WEST SUSSEX COUNTY COUNCIL CONSULTATION

TO:	Arun District Council FAO: James Cross
FROM:	WSCC - Highways Authority
DATE:	23 January 2020
LOCATION:	105 Victoria Drive, Bognor Regis, PO21 2DZ
SUBJECT:	BR/289/19/PL Demolition of existing garages & construction of 1 No 1 bed & 1 No 2 bed flats adjoining existing building.
DATE OF SITE VISIT:	N/A
RECOMMENDATION:	Advice
S106 CONTRIBUTION TOTAL:	N/A

Ground Floor Plan

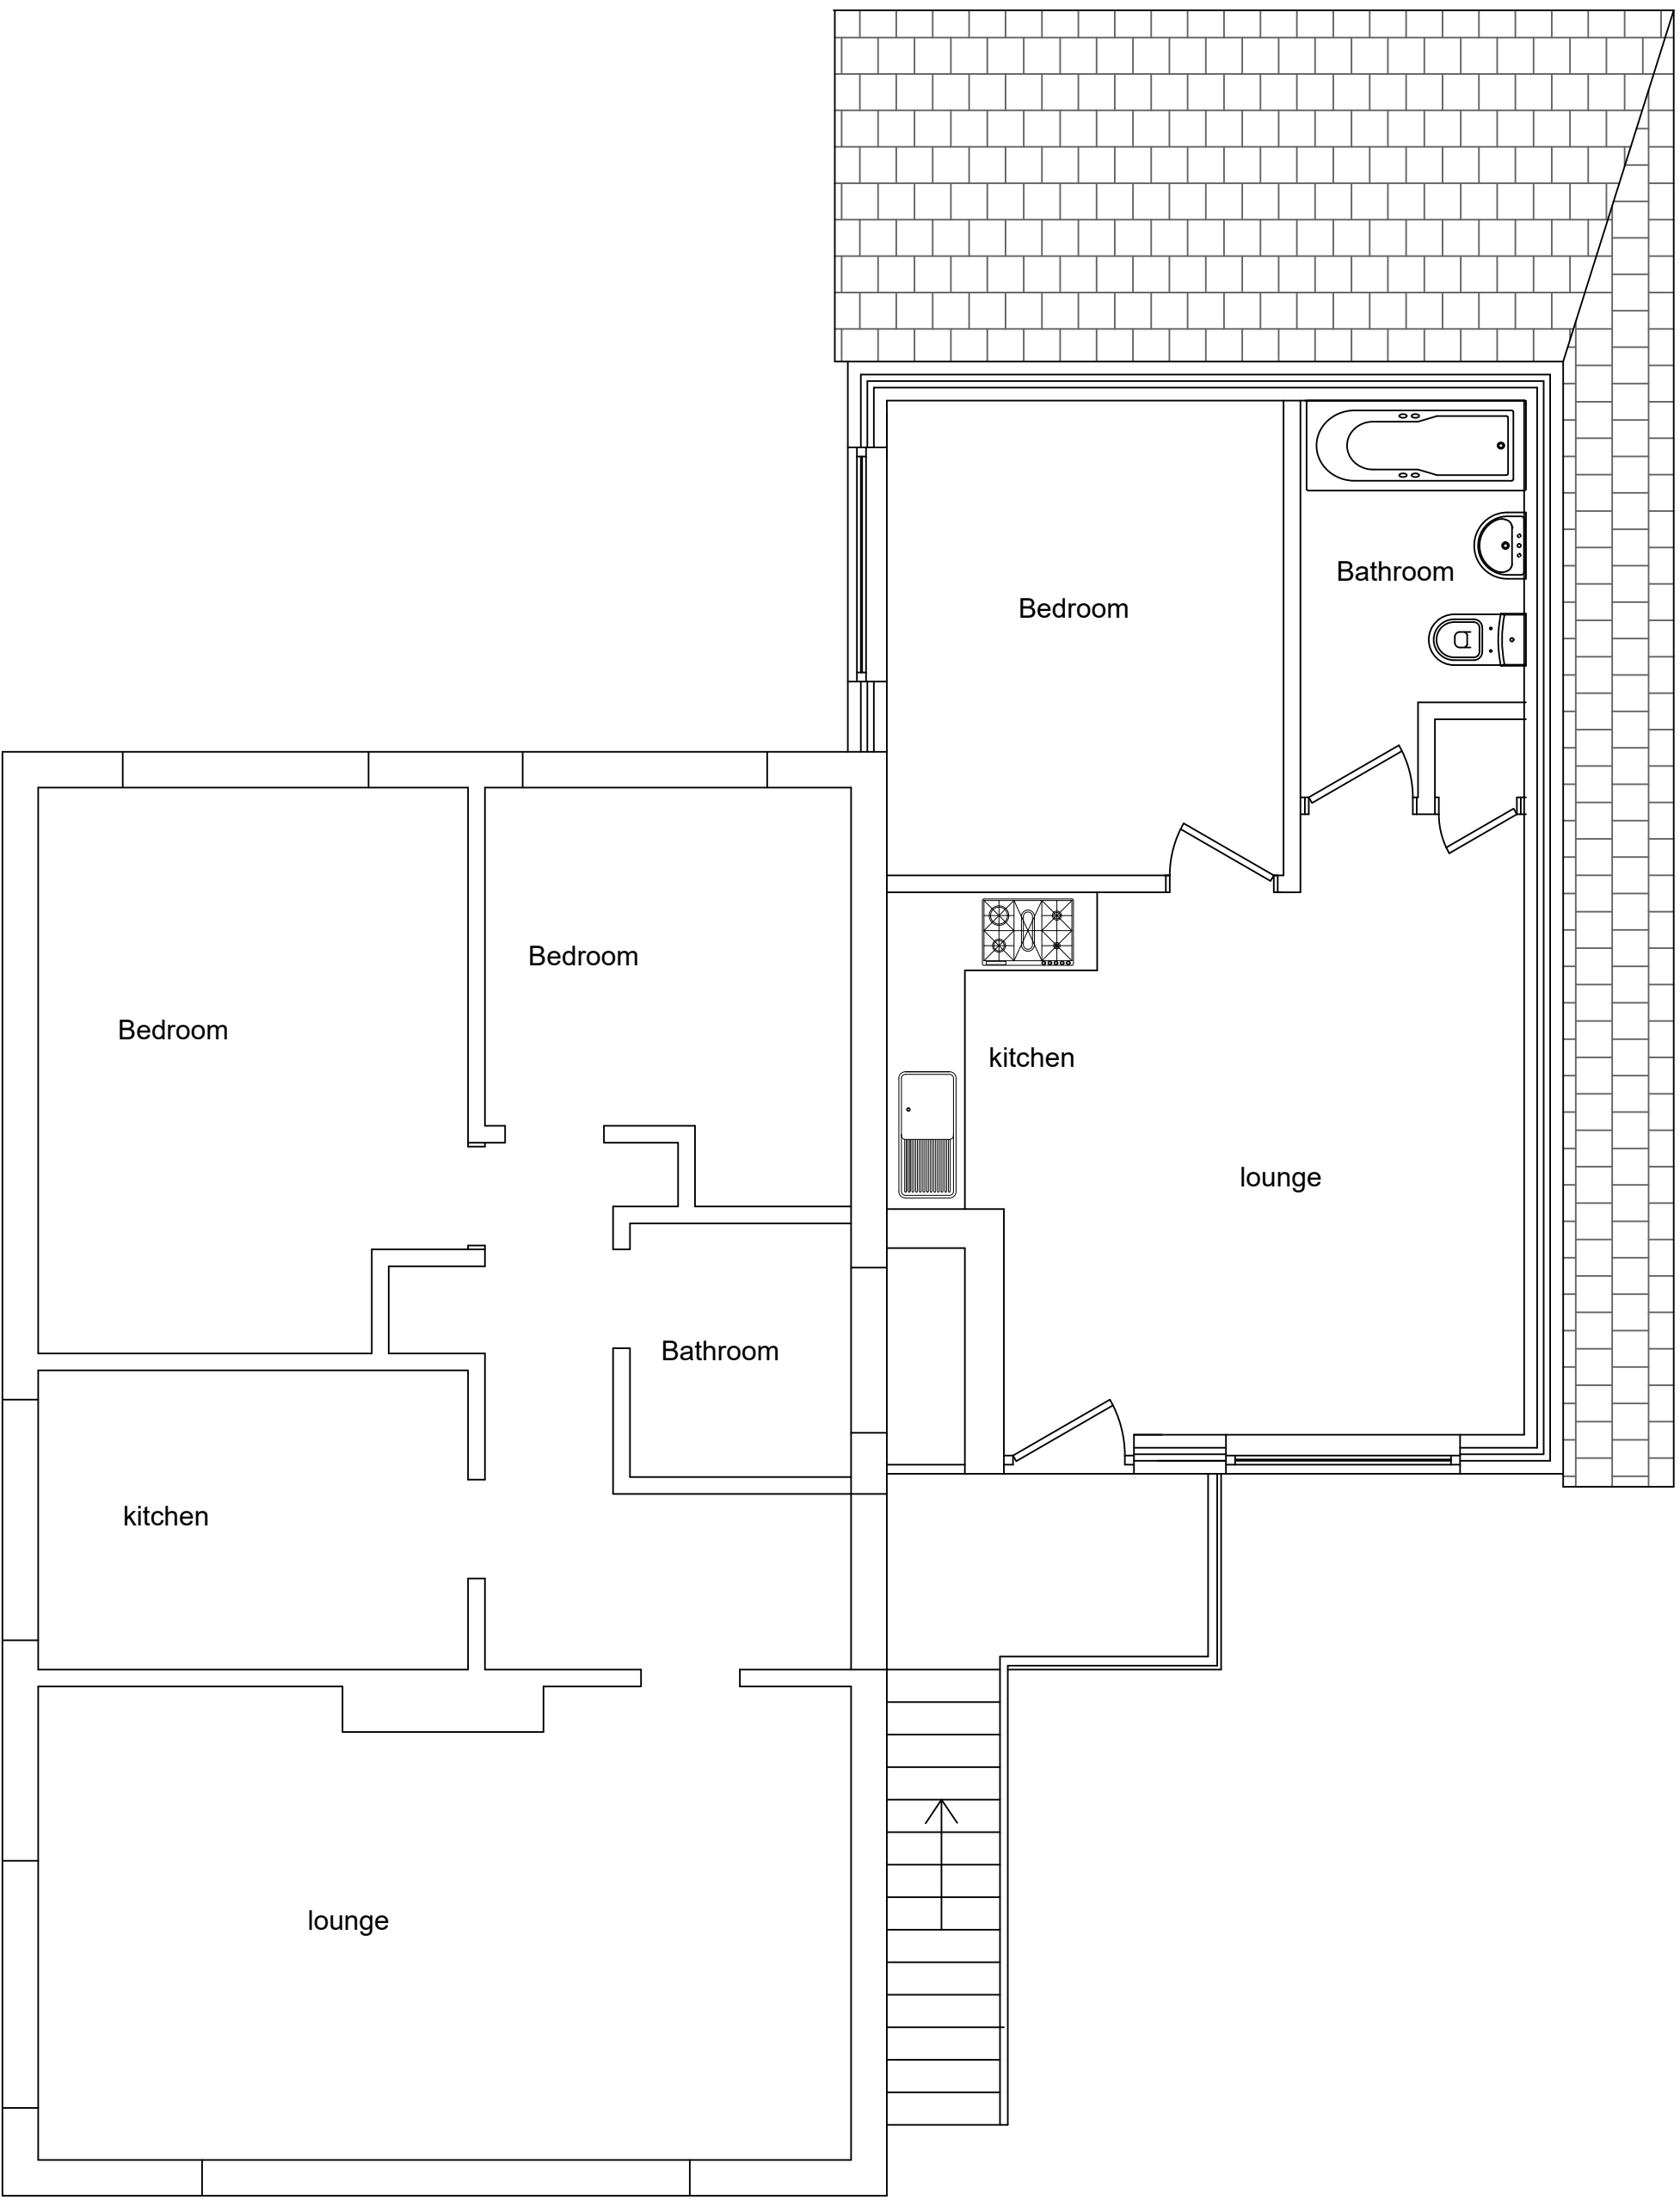
The applicant proposes to utilise the existing access and also create a second access onto Victoria Drive. The new access will require a dropped kerb, which is subject to a vehicle crossover (VCO) licence. A licence can be obtained through the local Area Office and VCOs must be constructed to a specification agreed with the local Area Engineer.

The applicant should be aware that the Area Office does not grant licences for second accesses in urban areas, unless significant safety or community benefits can be identified. This is in order to maintain as much on-street parking as possible. The LHA has consulted the Area Office for Arun and will forward on any comments in due course. The applicant may wish to consider revising the plans to utilise the existing access only.

The applicant proposes four car parking spaces for this development. The parking area is of sufficient size to allow for four car parking spaces that meet the minimum specifications for single car bays of 2.4m x 4.8m as set out in MfS. The WSCC Car Parking Demand Calculator indicates that the four dwellings would create a combined parking demand of five car parking spaces. Therefore, any overspill parking would have to be accommodated on-street.

In terms of cycle parking, the applicant proposes a communal cycle store. WSCC parking standards would require a cycle parking provision for at least four bicycles for this site. The inclusion of cycle parking helps promote the use of sustainable alternative modes of transport to the private car.

The proposed parking arrangement will compromise the ability for some vehicles to turn on-site, if all the parking spaces are full. As such, vehicles may have to exit the site in a reverse gear. However, Victoria Drive has good forward visibility and neighbouring properties appear to operate similar arrangements with no known safety concerns.

No part of the development shall be first occupied until the car parking has been constructed in accordance with the approved site plan. These spaces shall thereafter be retained at all times for their designated purpose.

No part of the development shall be first occupied until covered and secure cycle parking spaces have been provided in accordance with plans and details to be submitted to and approved by the Local Planning Authority.
